West Yorkshire Police
Kirklees District

Designing Out Crime Officer

To: Nick Hirst Kirklees Council Planning Services	Ref: 2021/93567 Date: 8th October 2021
---	--

Site Location: Land off Westgate, Cleckheaton, BD19 5DR
Application Type: Erection of 194 Residential Dwellings

TYPICAL FENCE ELEVATION - 450 HIGH

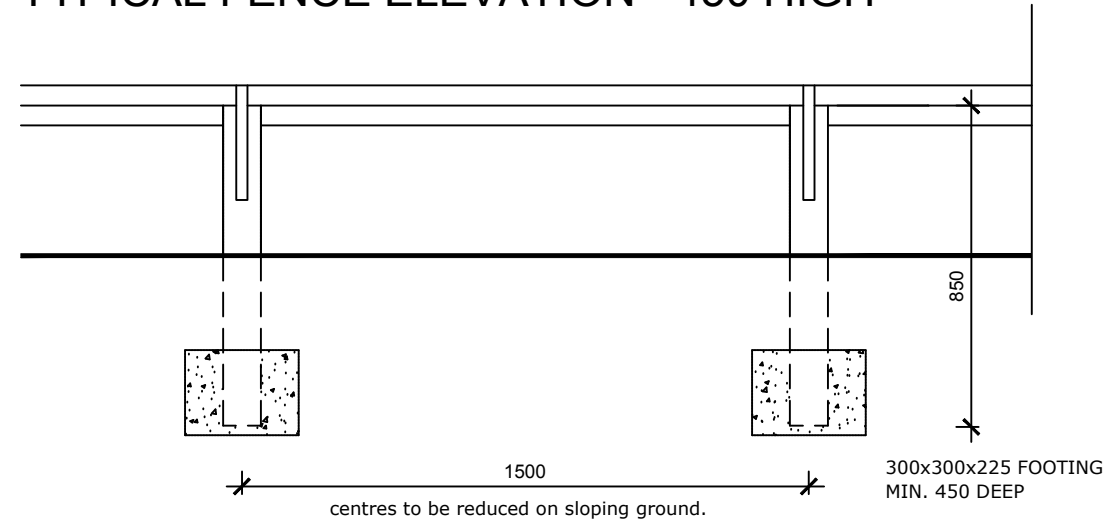
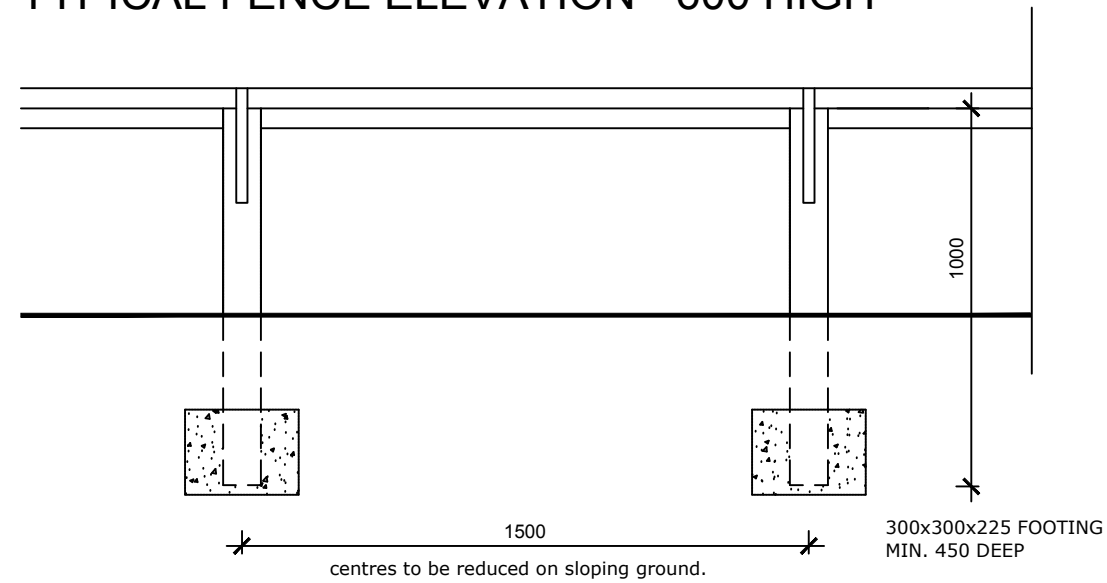
It is recommended the rear boundary treatments for each plot are to a height of 1800mm such as masonry materials, close boarded timber fencing or other durable materials. Rear plot dividers in height of 1800mm consisting of the same material as above should be installed between properties.

Additional trellis topping fencing can be added to the top of any fencing to enhance the security and prevent climbing access. This type of fence topping is fragile and will break when climbed. It also allows for better natural surveillance through the fencing.

All external facing boundary treatments **MUST** be smooth faced with no footholds or cross members to enable climbing access.
